Our Ref: EG/35/12/
Your Ref:

Town & Country Planning Act 1990 (as amended)
Town and Country Planning (Development Management Procedure) (England) Order 2010
Application for Planning Permission

Development Retention of horse-box hire business, mobile home, office/staffroom and an area of hardstanding.
Location Longreach Eastergate Lane Eastergate

TITLE	SITE PLAN
ADDRESS	LONGREACH EASTENGATE LANE PO20 3SS
SCALE:	1:200

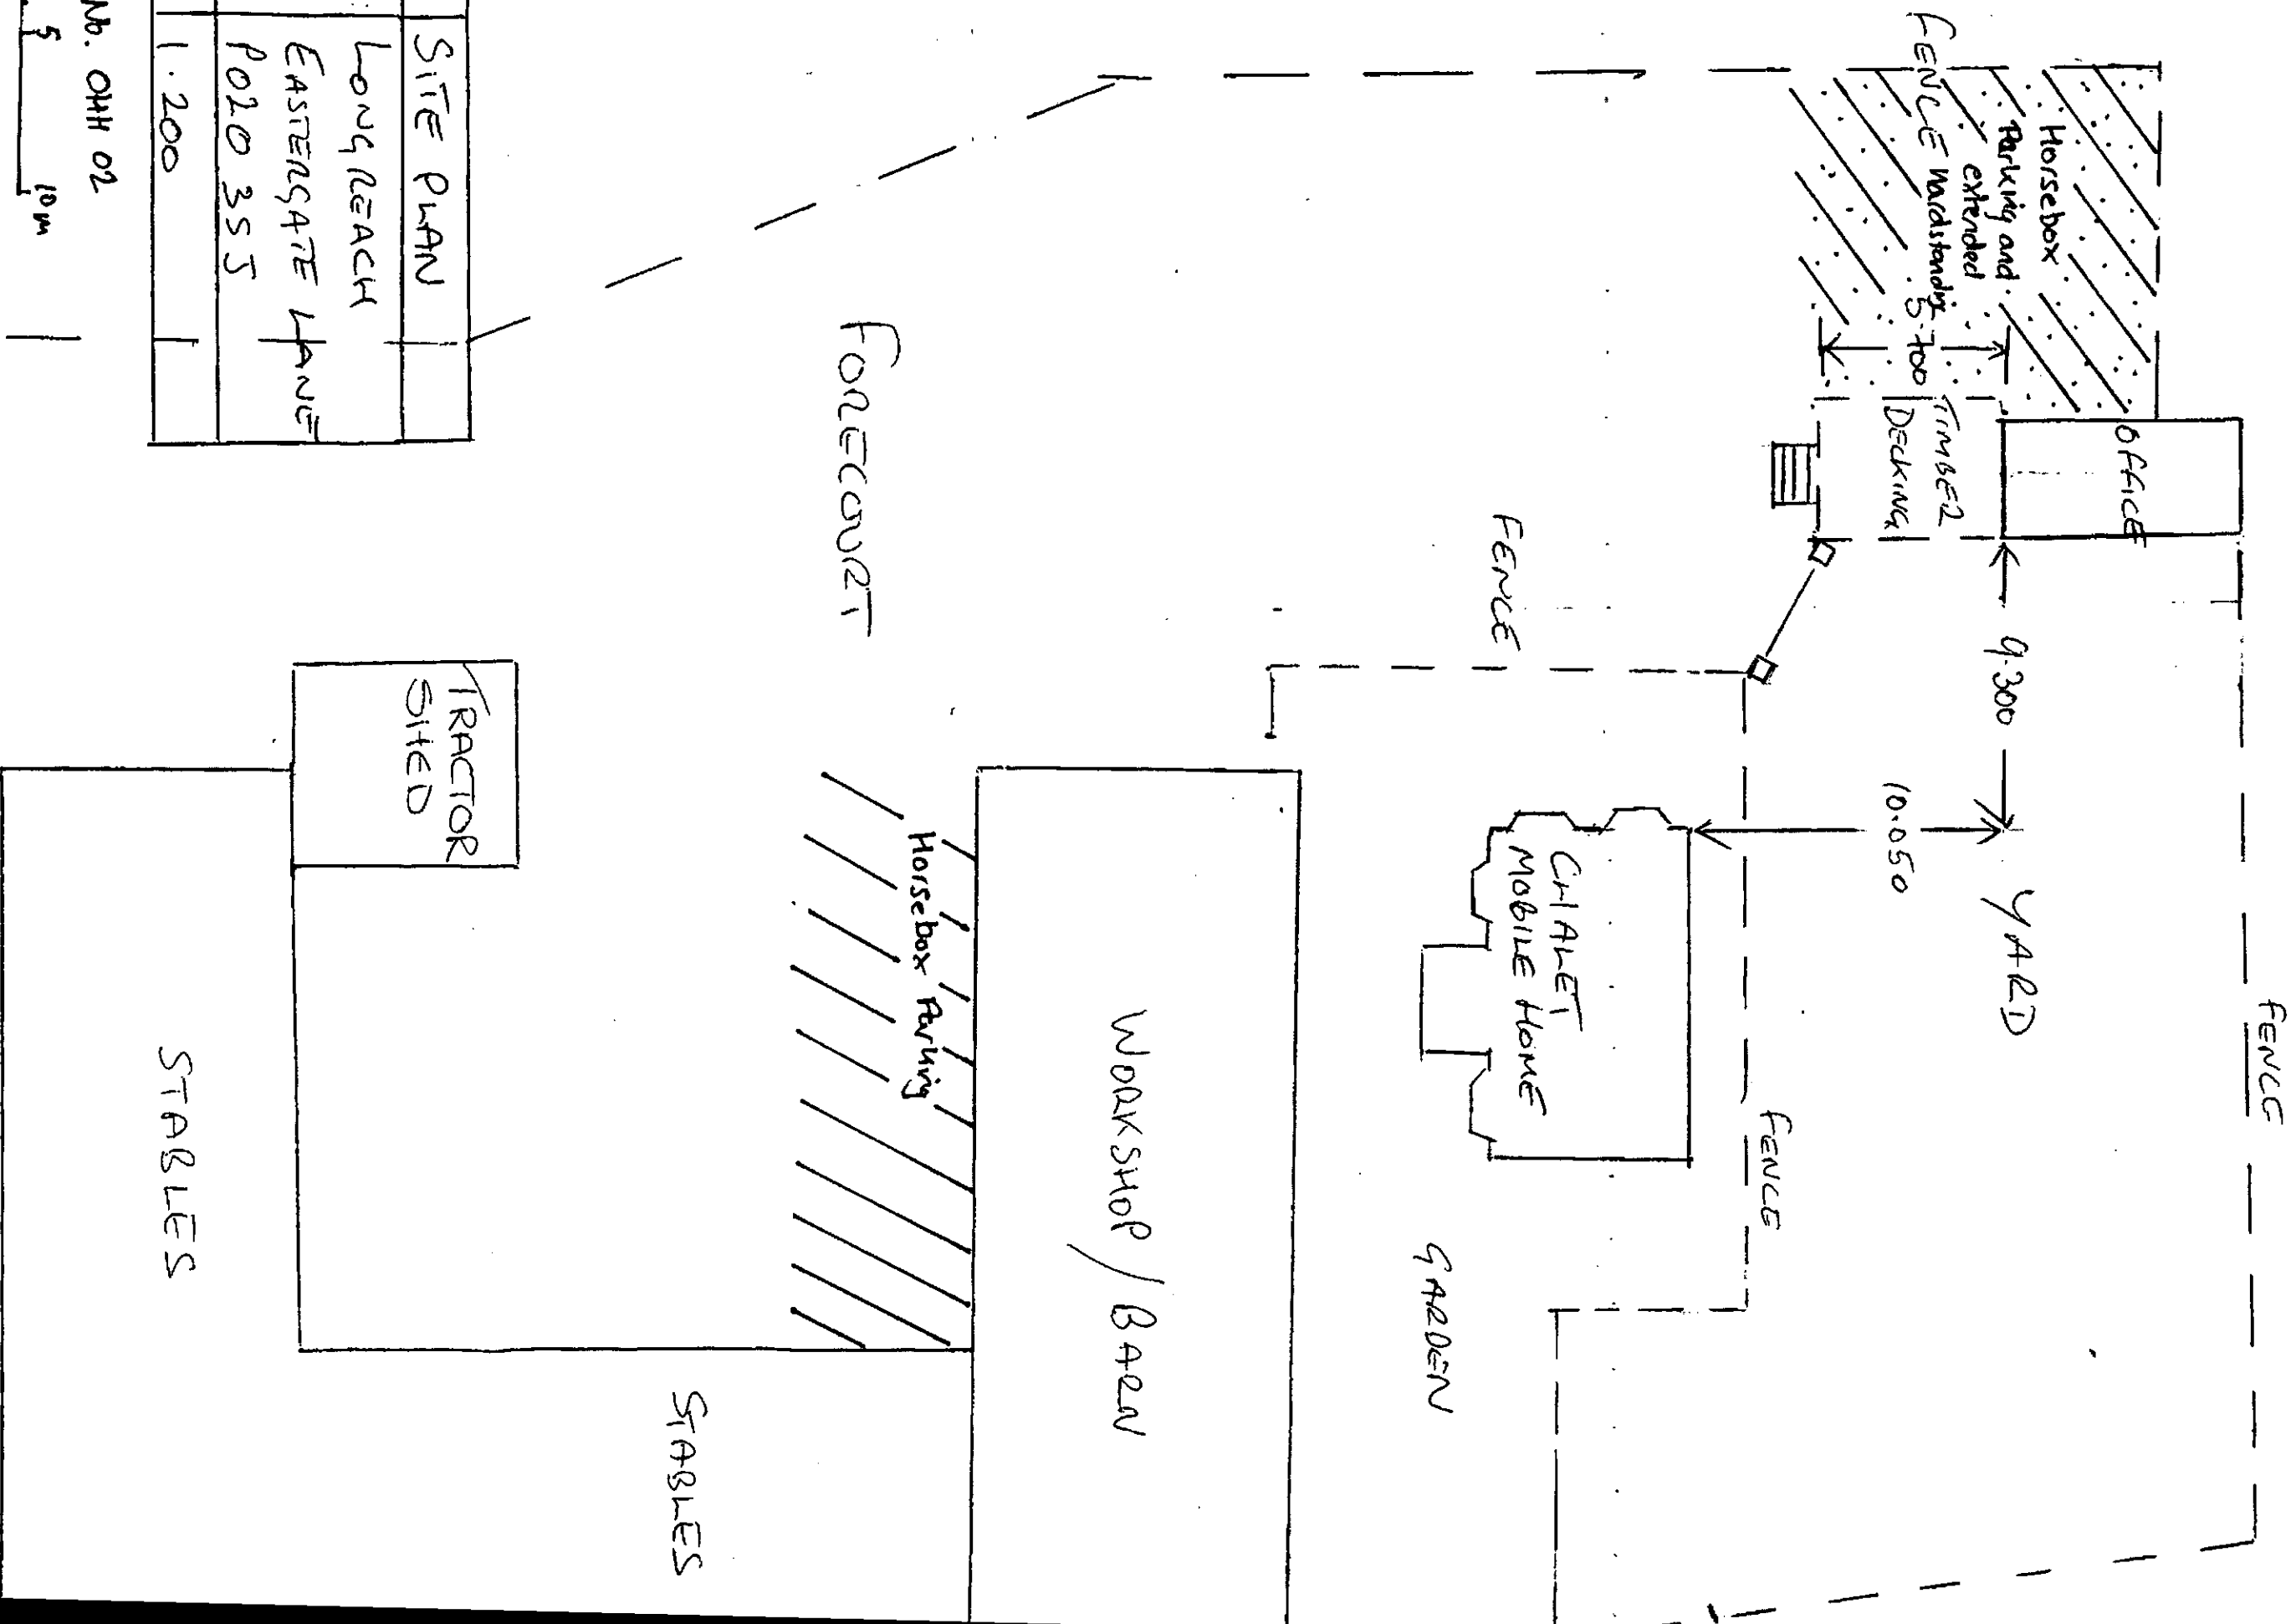
incorrect I require 1 electronic or 3 paper copies of a block/site plan in accordance with the guidance notes available on our website detailed below (click on National List). Also, please show the decking for the office, the layout of the siting/parking of storage boxes. — *1 named road*

OFFICE ELEVATIONS

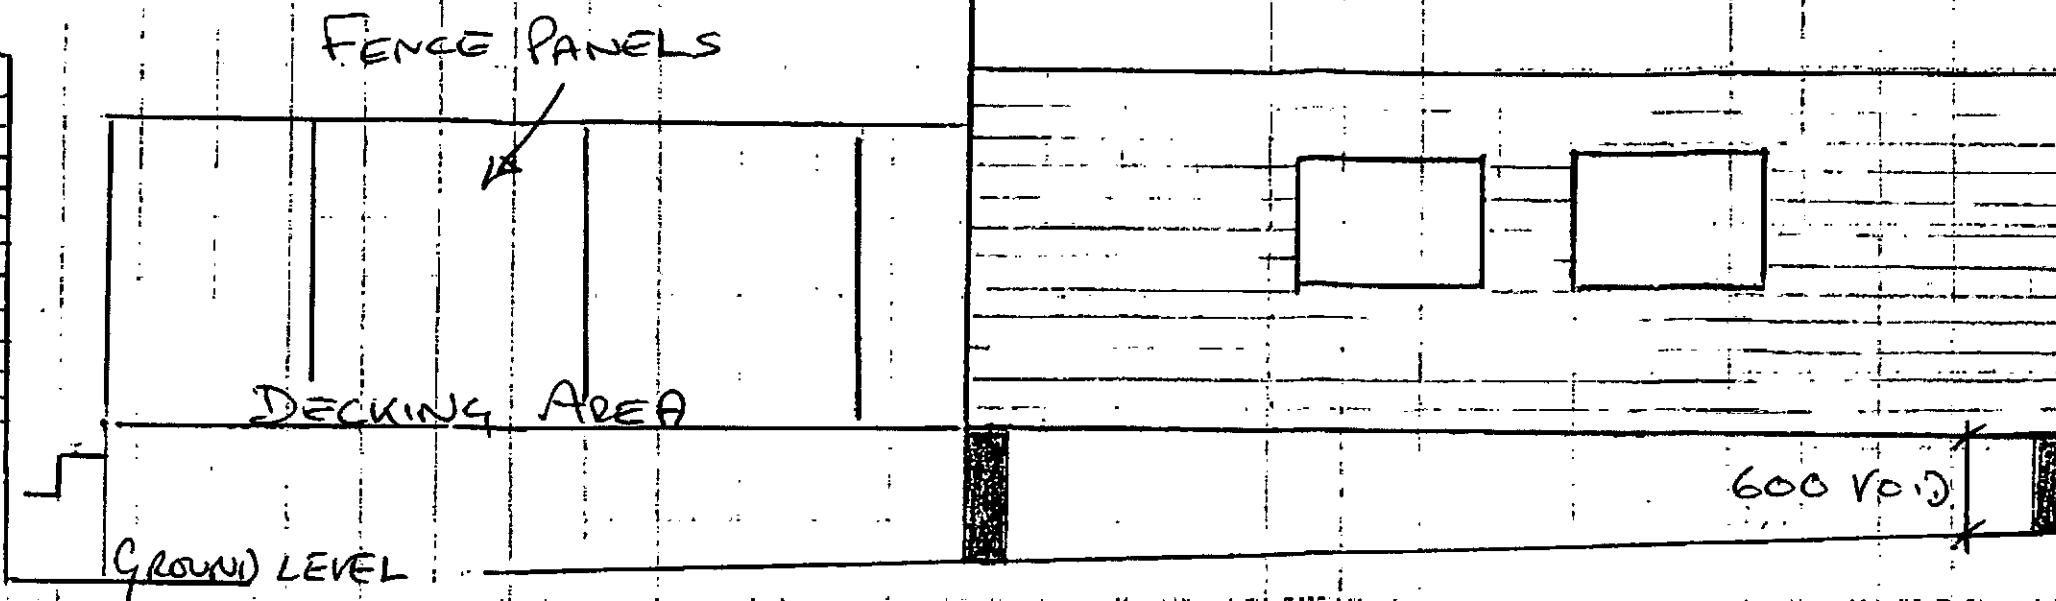
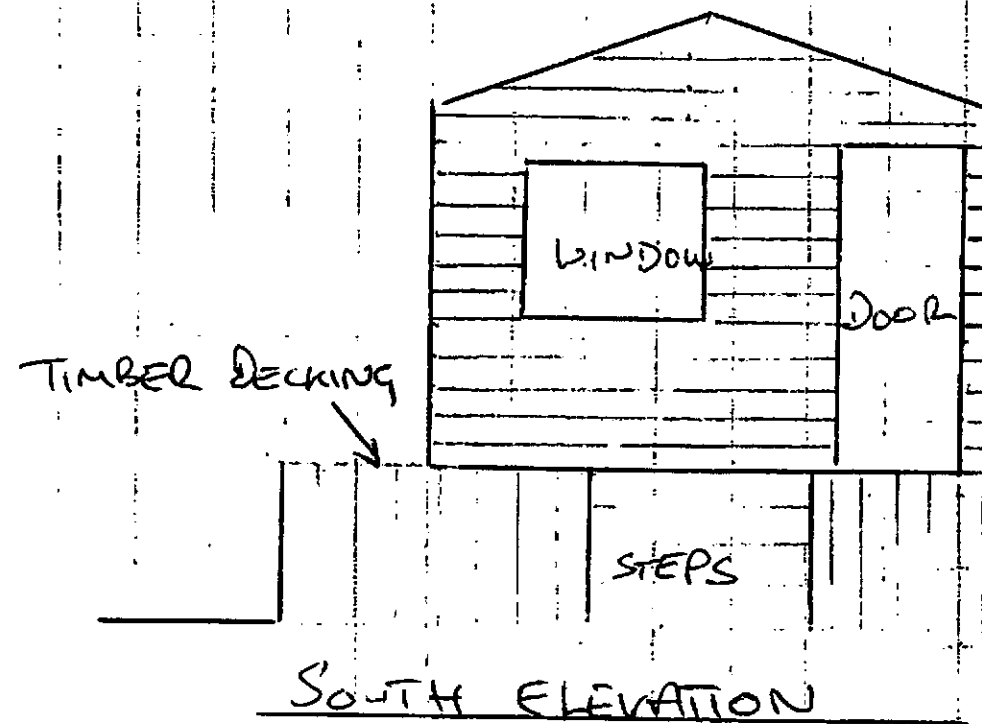
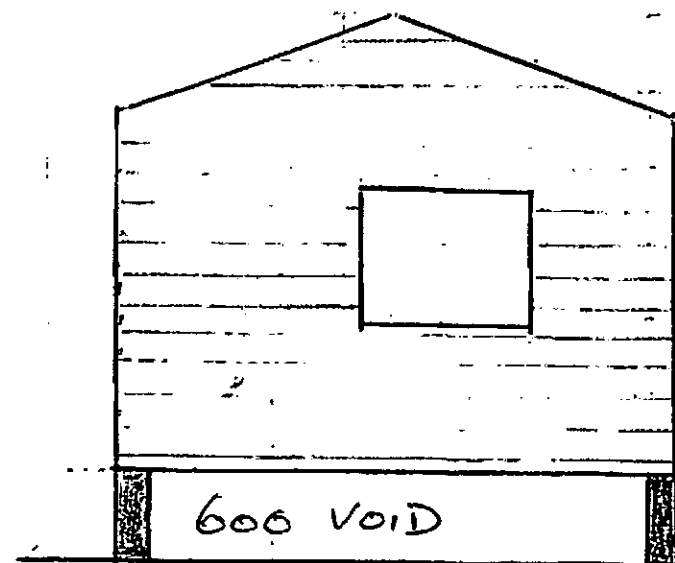
Please provide 1 electronic or 3 paper copies of ~~existing and proposed~~ elevations for the mobile home and the office/staff room in accordance with the guidance notes available on our website detailed below (click on National List). FULL PLANS FOR OFFICE/STAFF ROOM

Site Location Plan

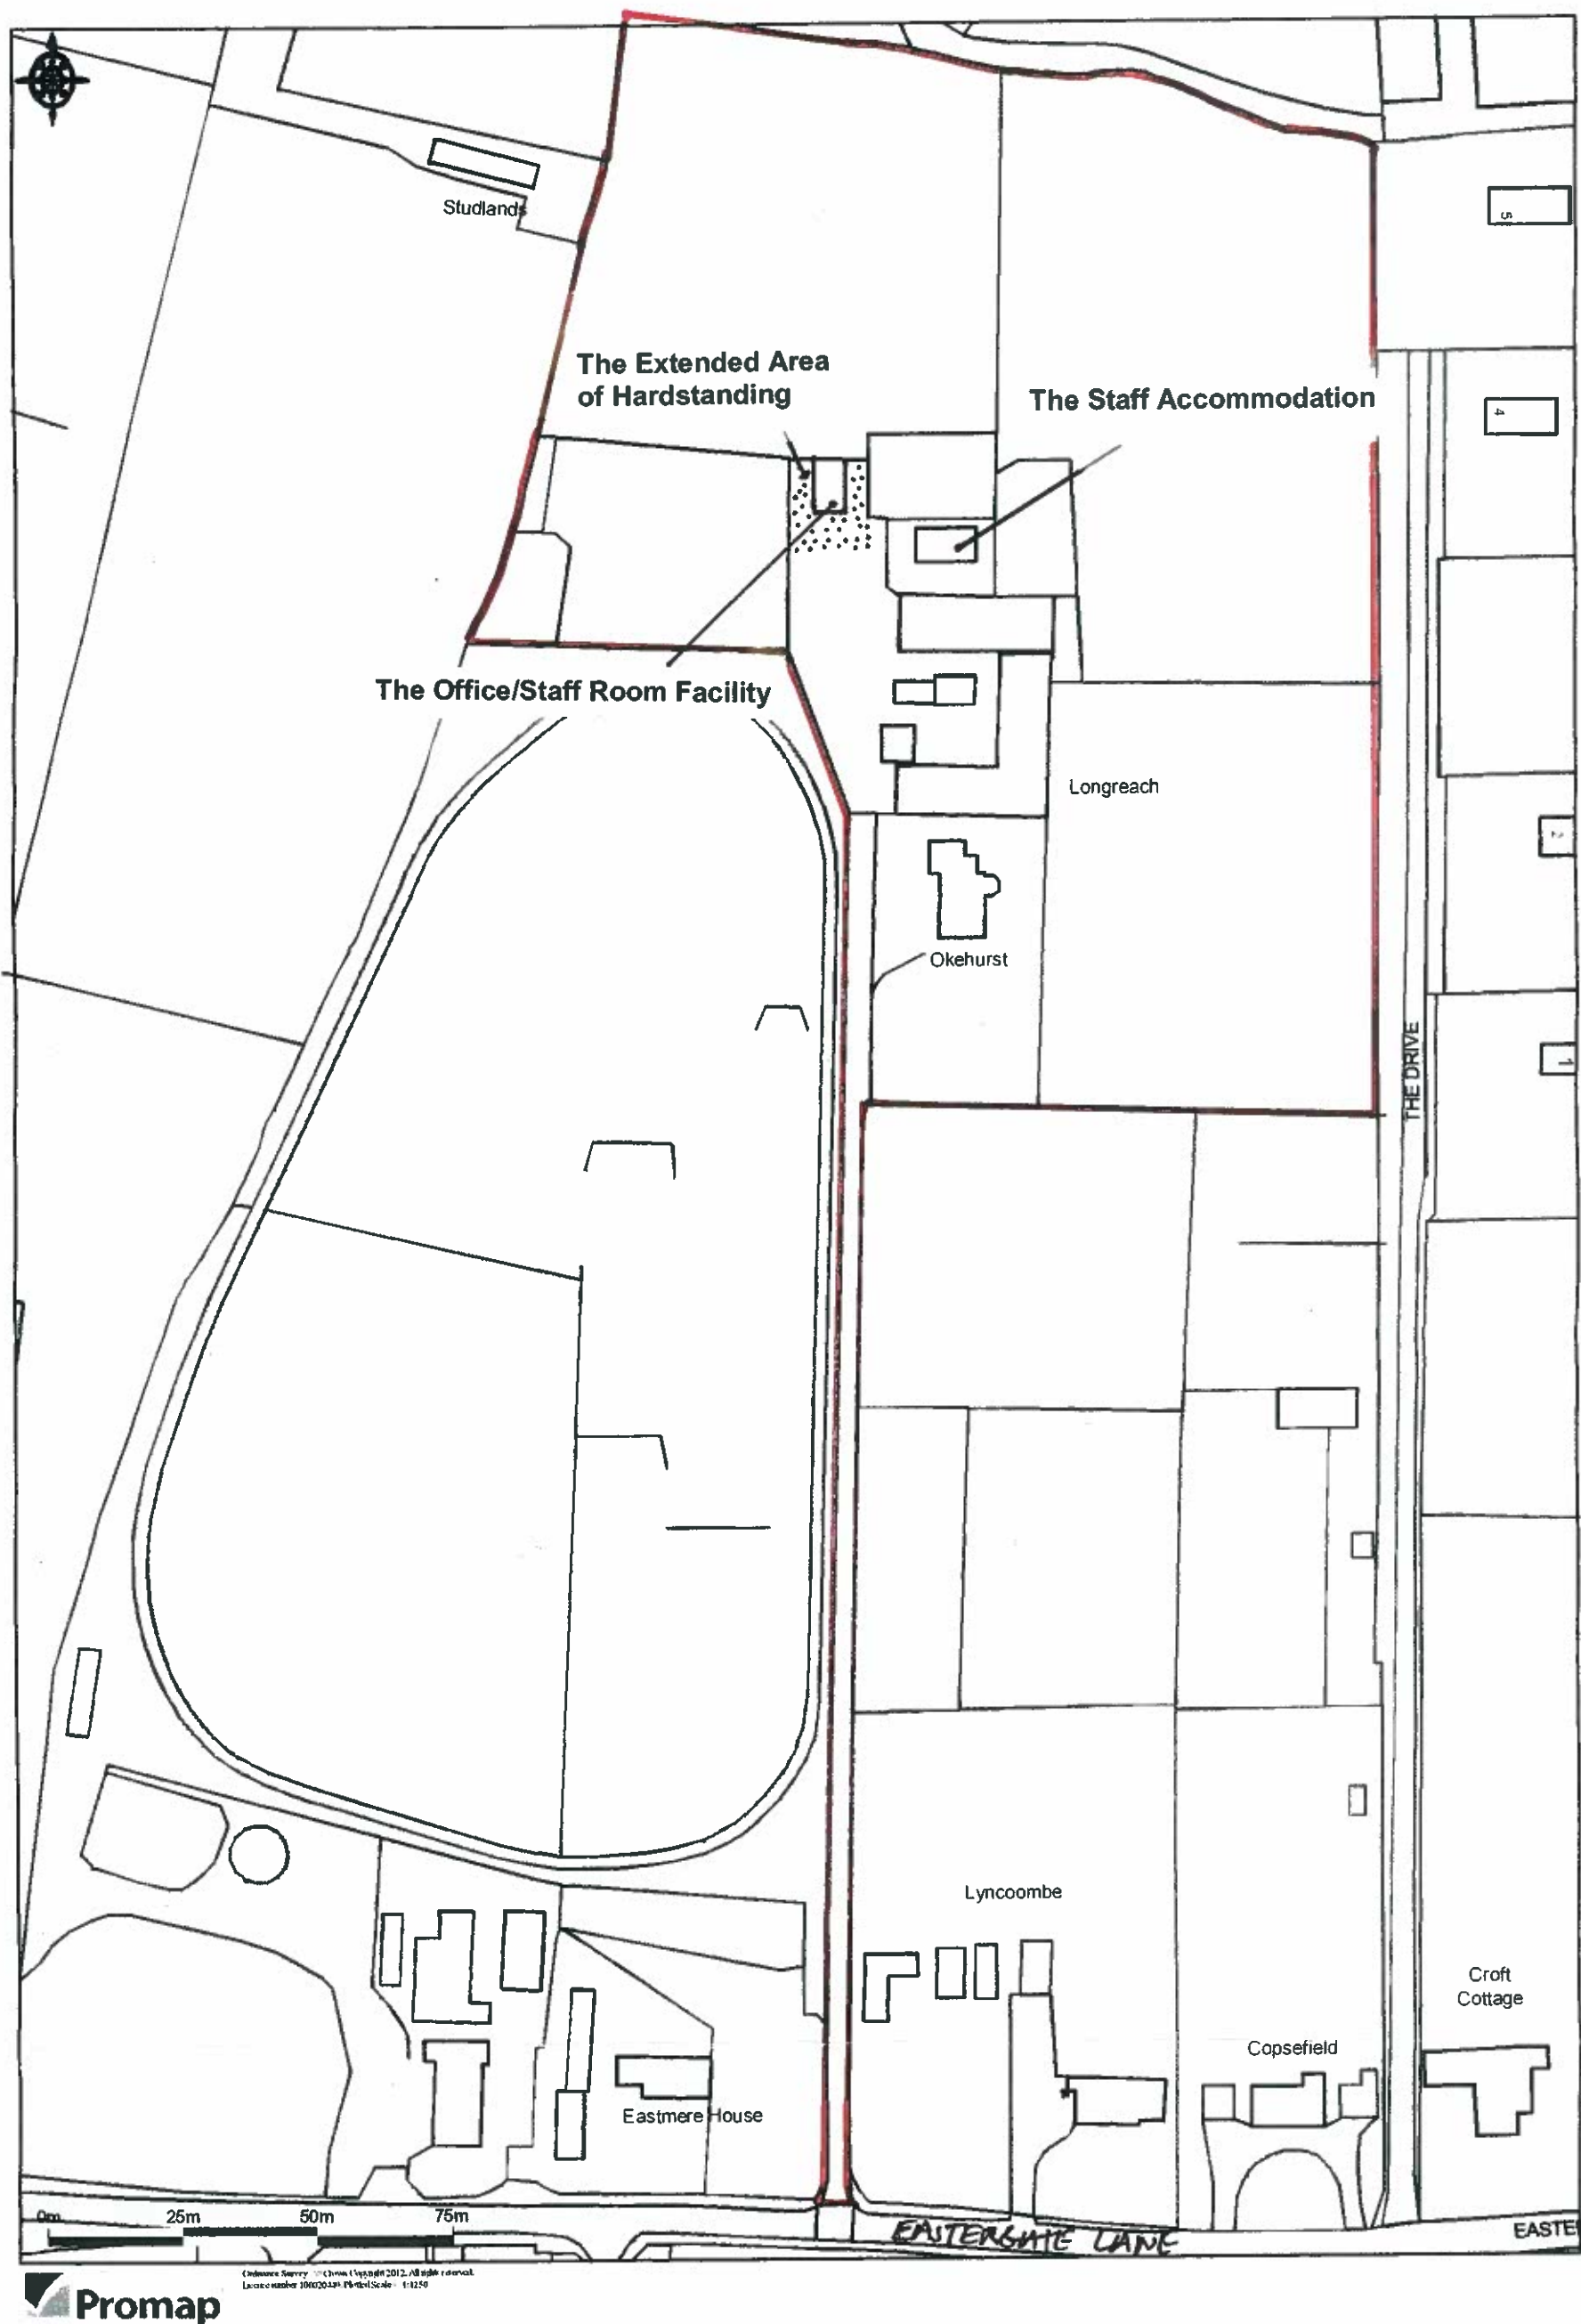
I require 1 electronic or 3 paper copies of a location plan in accordance with the guidance notes available on our website detailed below (click on National List). Please provide another named road. ✓

Flood Risk Assessment

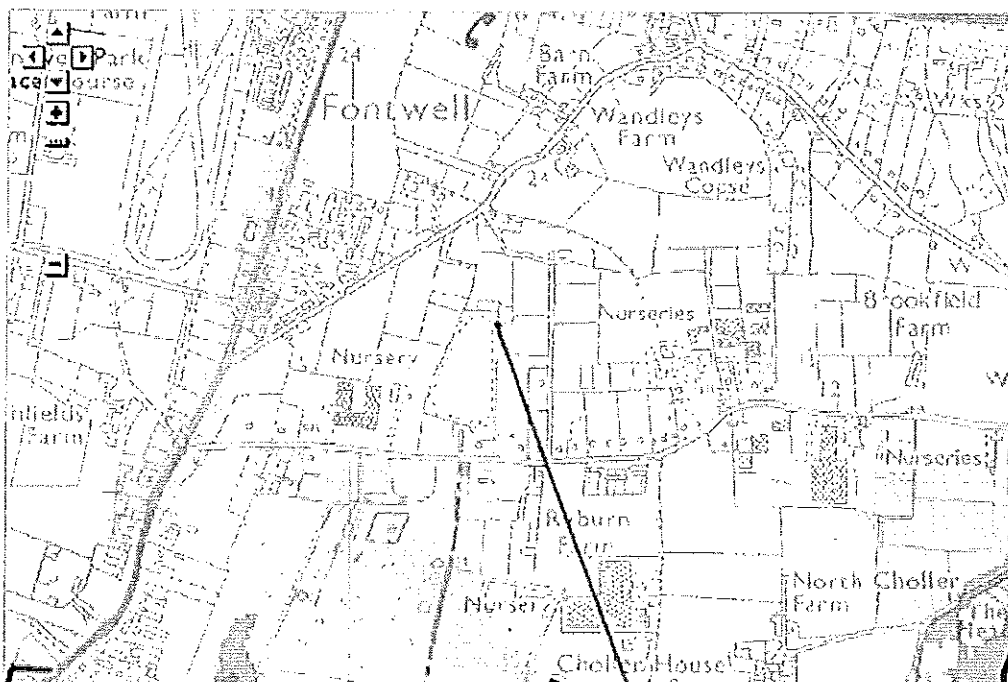
← This application requires a Flood Risk Assessment. Please refer to the guidance notes available on our website detailed below (click on Local List)
